ADC PARKS & GREENSPACE ARBORICULTURE

PLANNING APPLICATION: BR/257/14/T

ADDRESS: 106 Chichester Road Bognor Regis PO21 5AA

BRIEF DESCRIPTION: Prune back crown to 1No. Common Beech to give 2m clearance to property on North-East side within 6-12 months, remove stem on North-East side of 1No. Walnut Tree.

- 5.1.8 **Photograph 6:** View of fungal fruiting body and advised pruning cut.

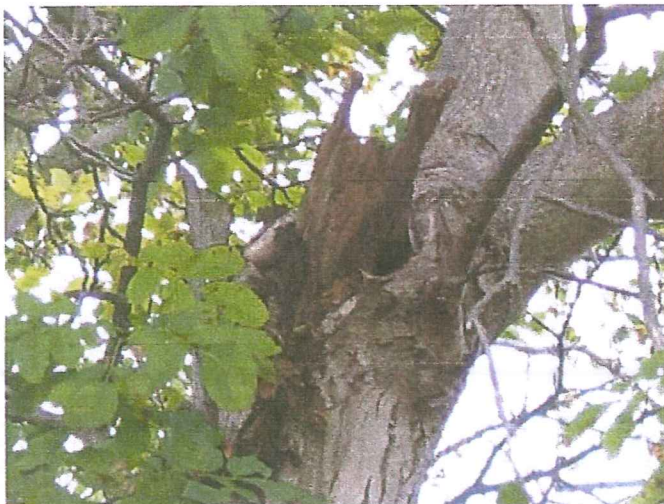
- It is also apparent from the site inspection that **T4** has extensional growth that is growing out of the North/eastern stem. This stem, as highlighted in the submitted report has the presence of the pathogen *Inonotus hispidus* just below a previous pruning point. As a white rot fungus, *Inonotus hispidus* is a concern because it can cause brittle fractures to occur in the areas of decay. The application has requested the extensional growth from this historical pruning point is reduced back. This measure will reduce the stress acting upon this union and therefore the risk of failure occurring in the outlined area of decay.

- **It would be my recommendation that the remedial pruning operation of instigating no more than an 2 meter buffer on T3 for the neighbours property should be allowed to take place**, as it is unlikely to have a lasting detrimental effect on the trees health and/or vitality. This operation is likely to alleviate any potential conflict experienced between this tree and the neighbours dwelling.
- **It would also be my recommendation that the proposed pruning operation of reducing the north-eastern stem of T4 by no more than 5 meters to the previous pruning point, should also be allowed to take place.** This operation will reduce the chance of a brittle fracture occurring in the pocket of decay located below the outlined pruning point.
